Condition 5- surface water drainage

Condition 6- discharge of flows to watercourse

Rate	July 20	Scale	1/200	Org. No.
own	EG	Chk'd	QA'D	424861-101P

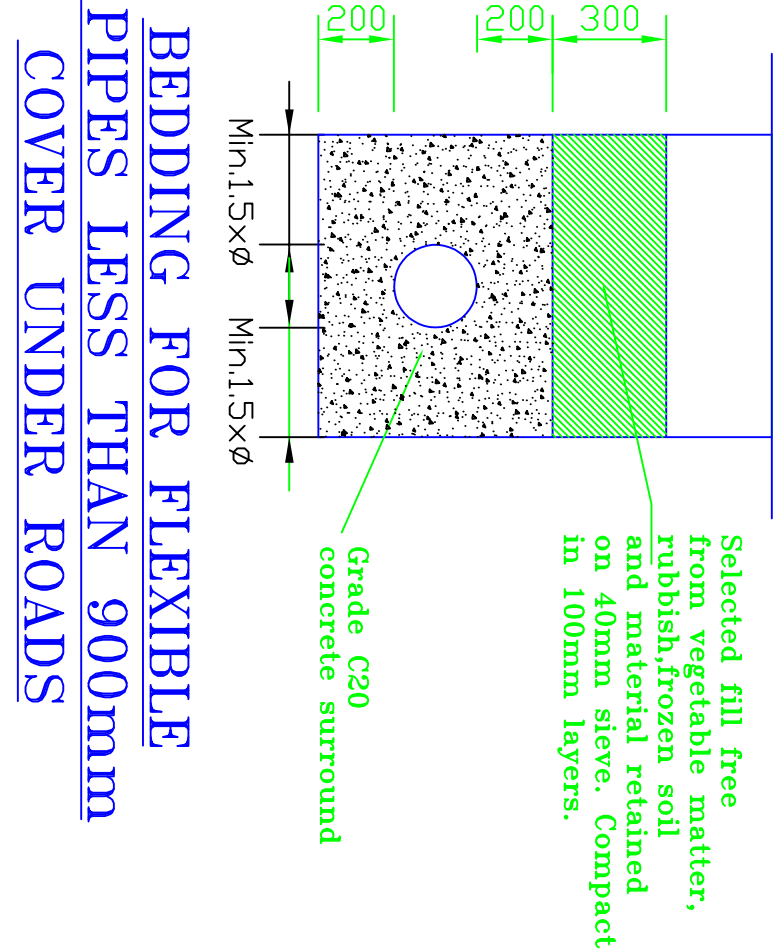
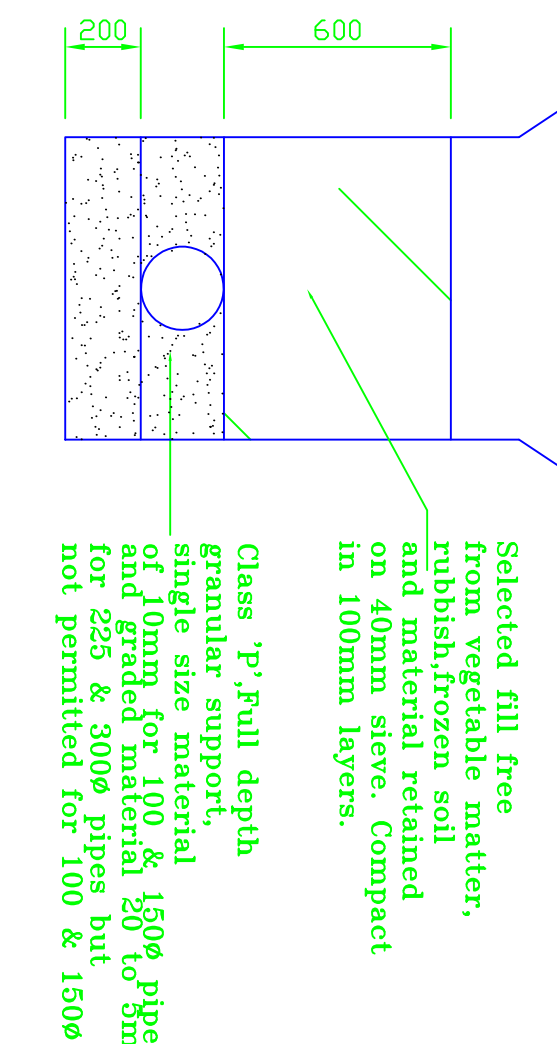
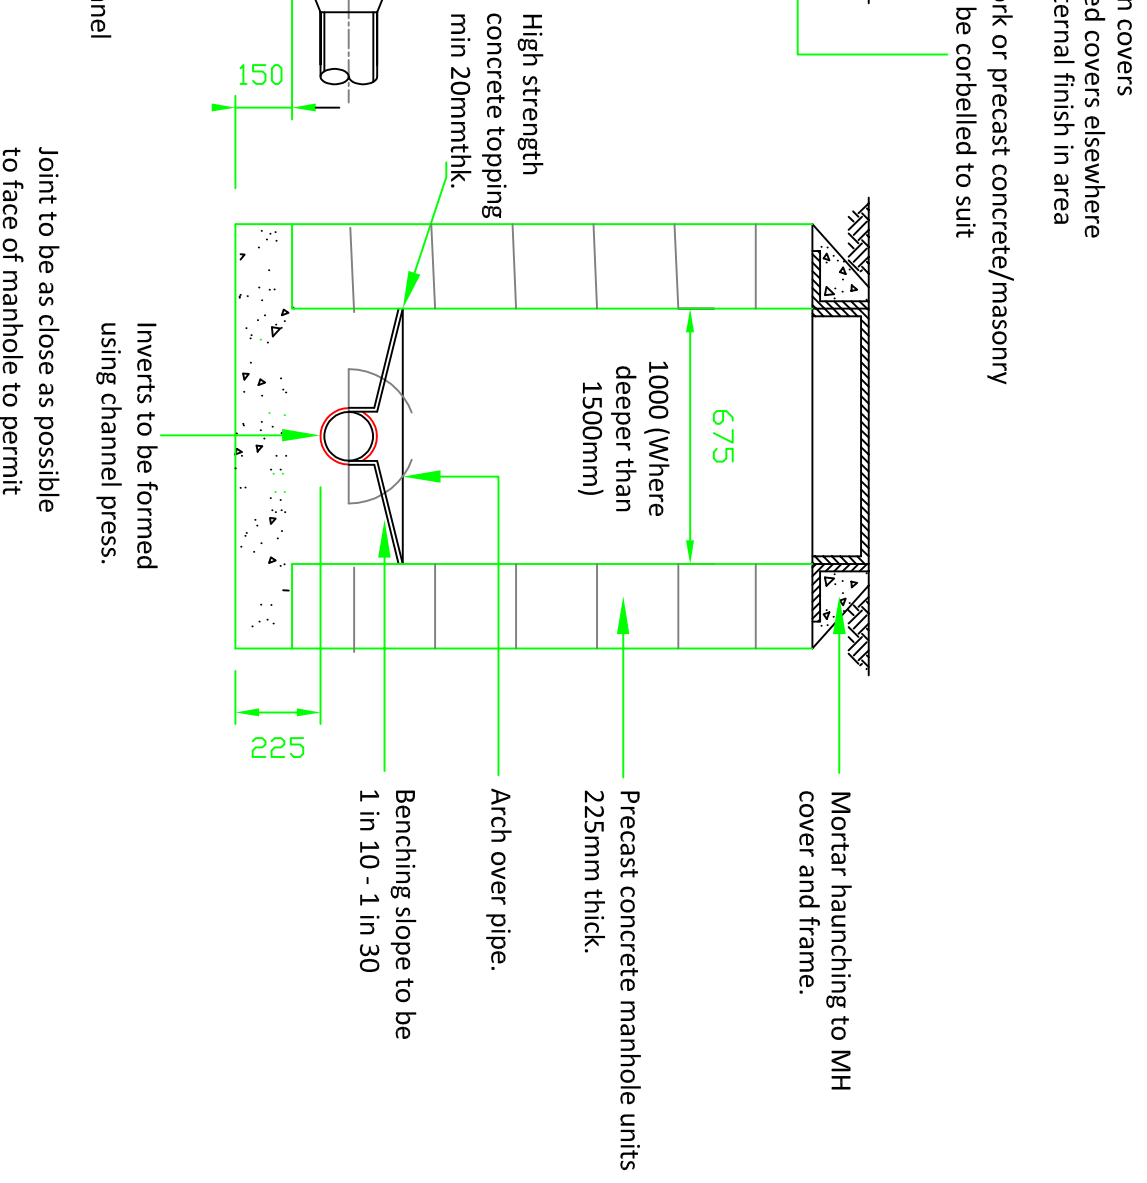
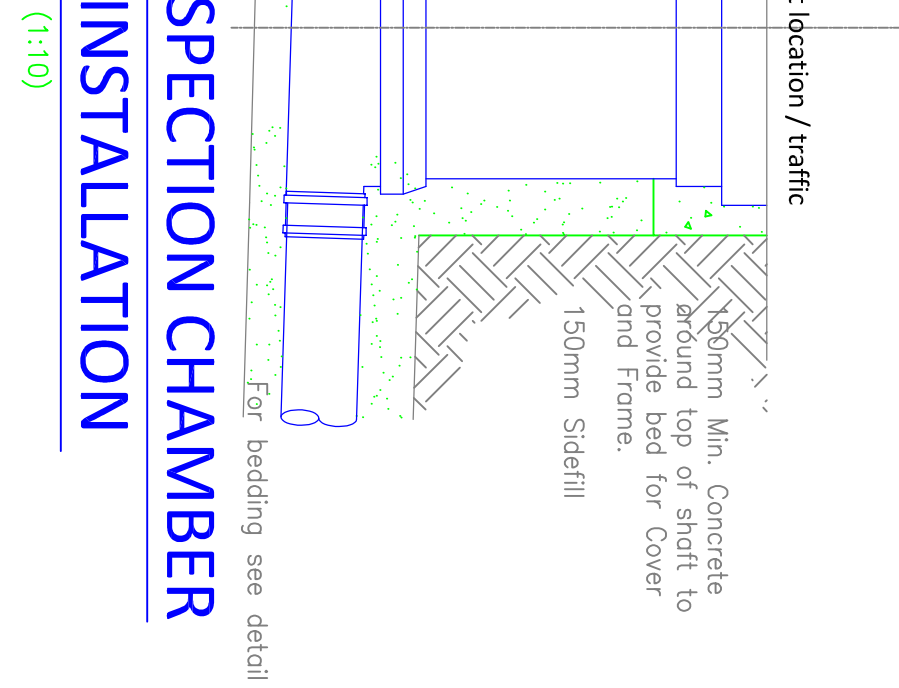
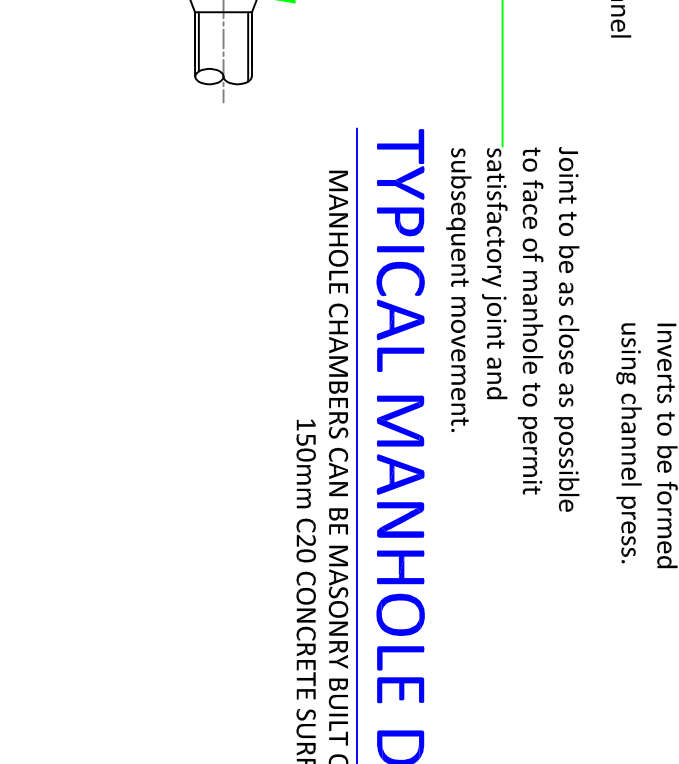
We also note that finish and formation levels must be shown on permeable paving and it must be accurately modelled to include any slope.

These are shown on the sectional drawings on the drainage details drawing and as noted above.

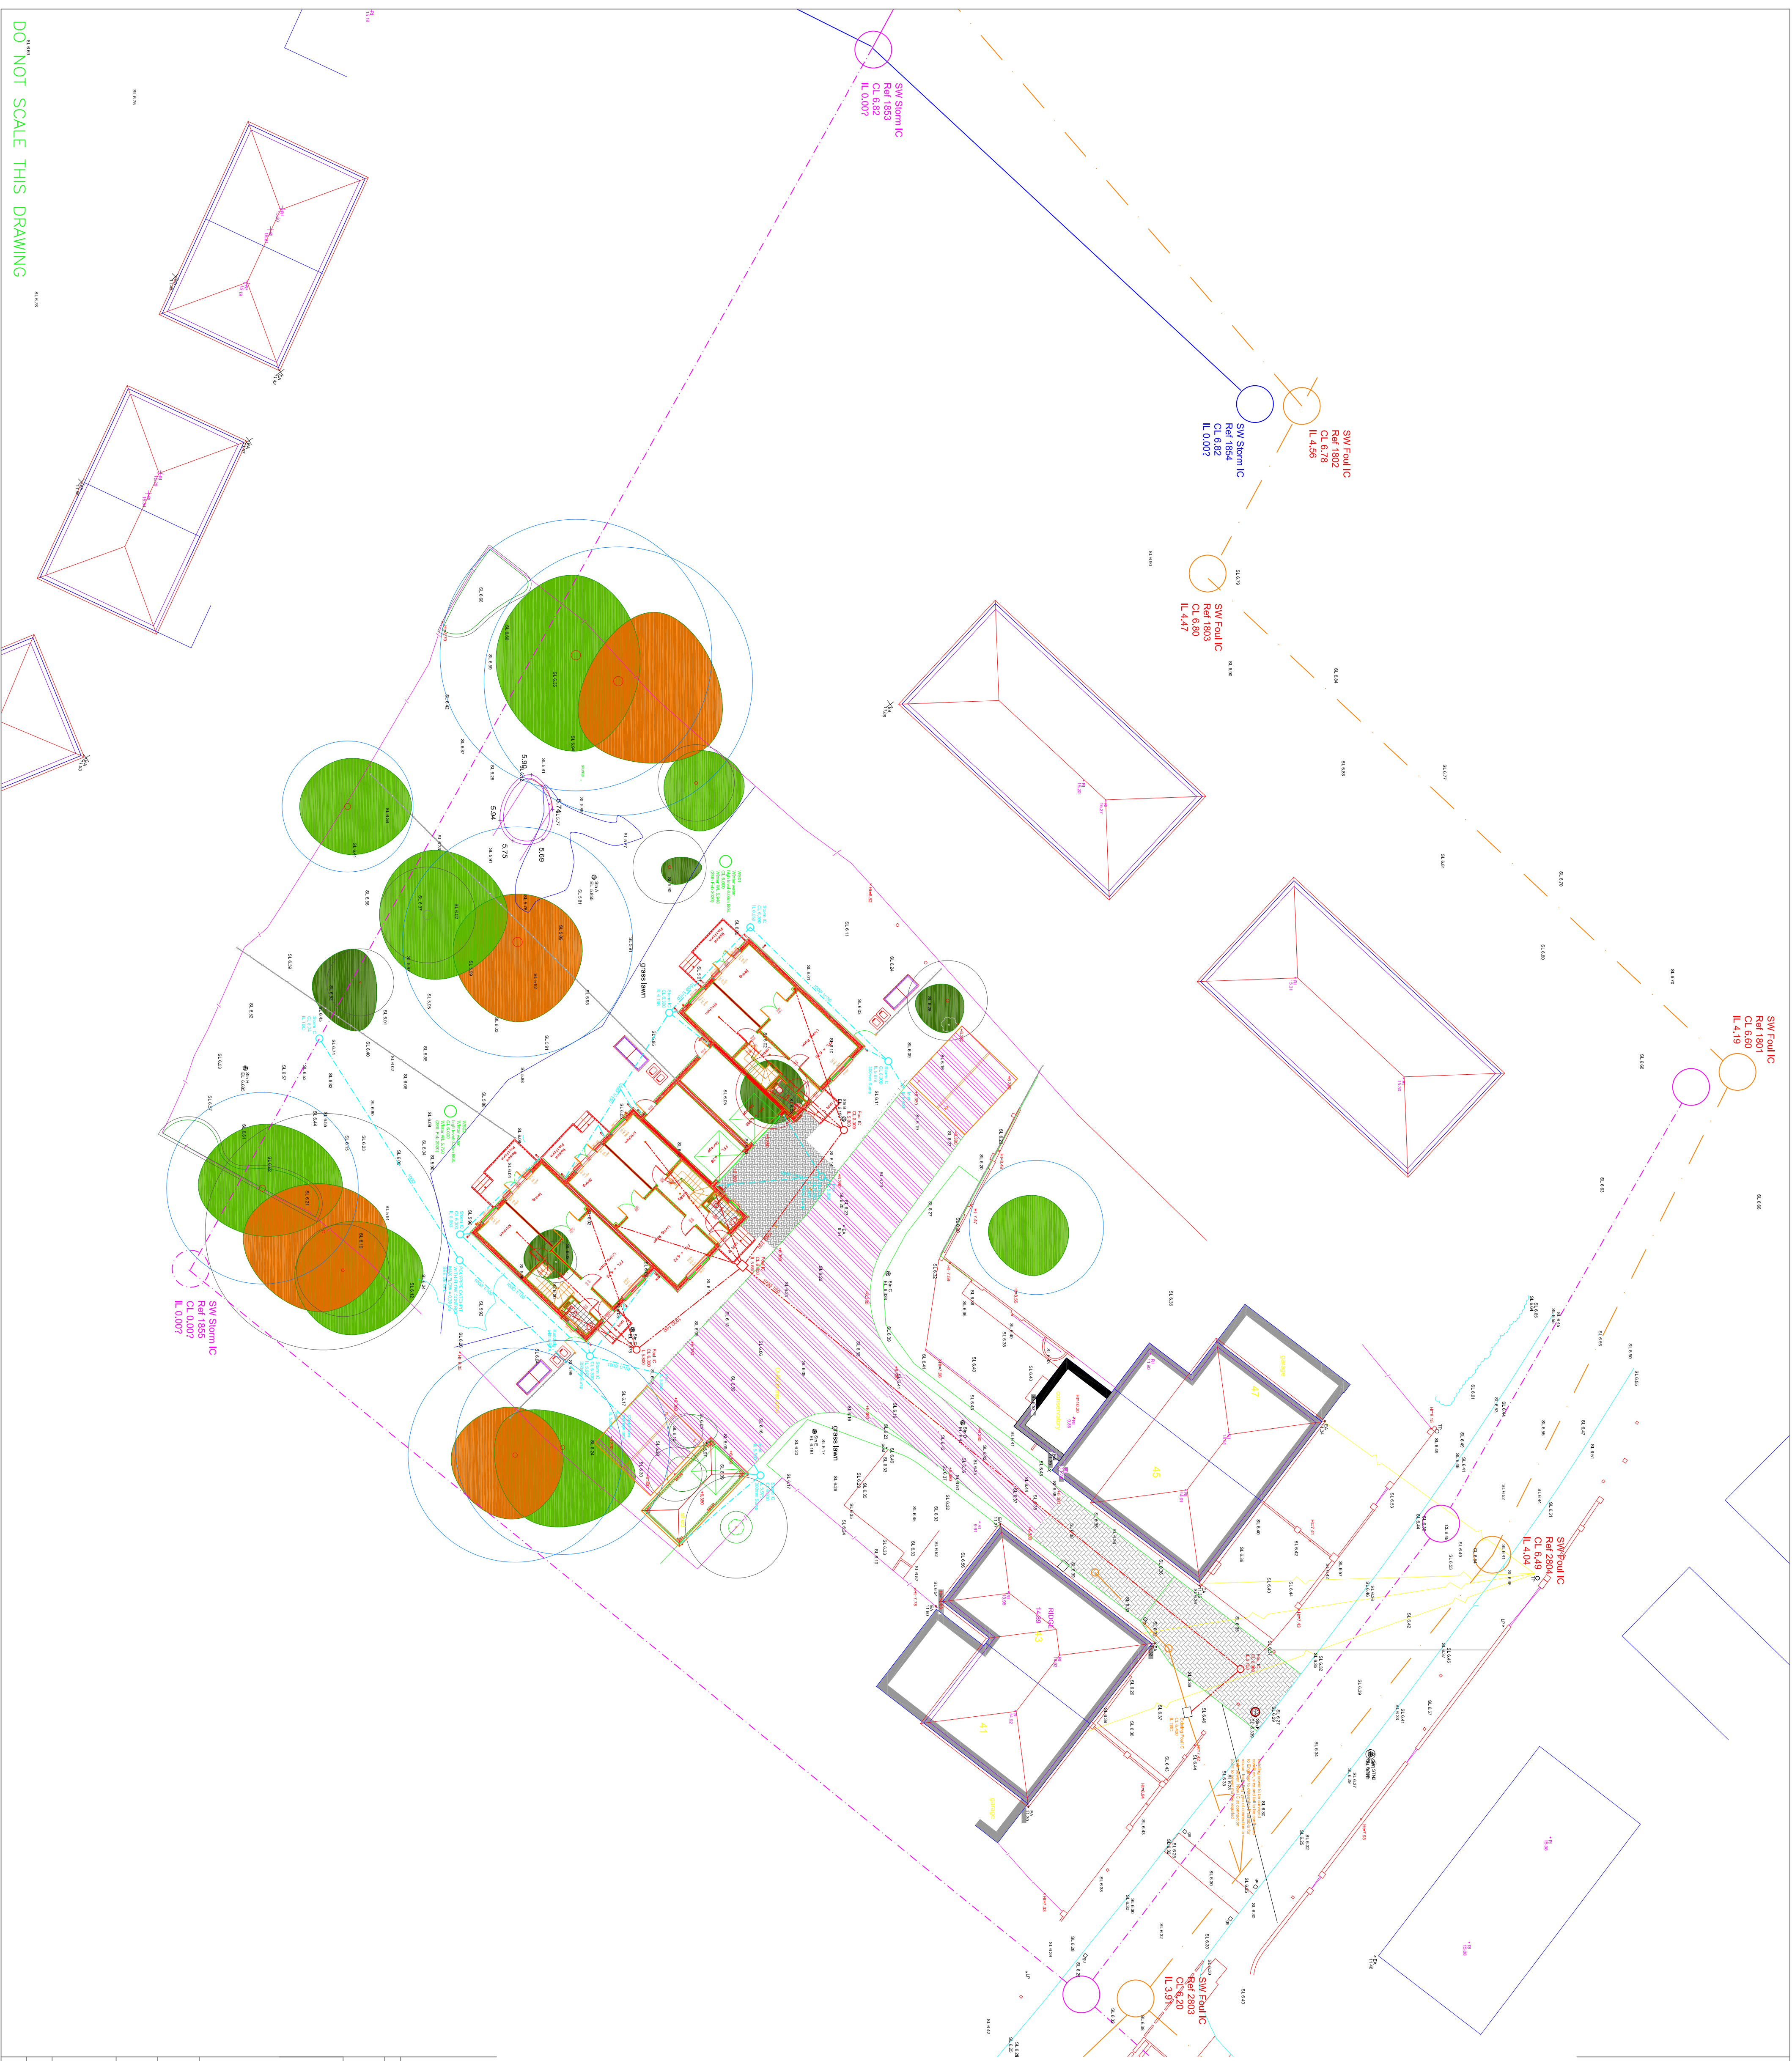
The documents submitted do not accord with the documents submitted to support the planning appeal. Details supplied to discharge this condition must tie in with this, specifically regarding levels and extent of permeable paving to ensure that flood risk is not increased elsewhere.

The discharge of condition application does not appear to acknowledge the requirement for providing flood mitigation and surface water drainage.

As detailed above the information provided is insufficient to demonstrate whether attenuated discharge to watercourse is required. This has now been added to the drawings as discussed above and we are expecting further dialogue on this matter with the LPA and Southern Water.

We have updated the calculations as noted below and increased the area of permeable paving and flood storage to allow for the required 35m³ of flood water storage loss caused on the site by the new development. We have also now proposed a tanked system as the project developer making the groundwater testing arguable less important (see below). The winter groundwater testing was carried out in accordance with appeal condition No. 5. There was no requirement that the local authority be consulted in advance to agree a methodology for the winter groundwater testing and we feel that the study locations were reasonable. Obviously from the results with the apparent ground water testing maximum level being so high a percolation test would have been impossible to perform. ~~would like to progress and not wait to undertake further winter monitoring.~~
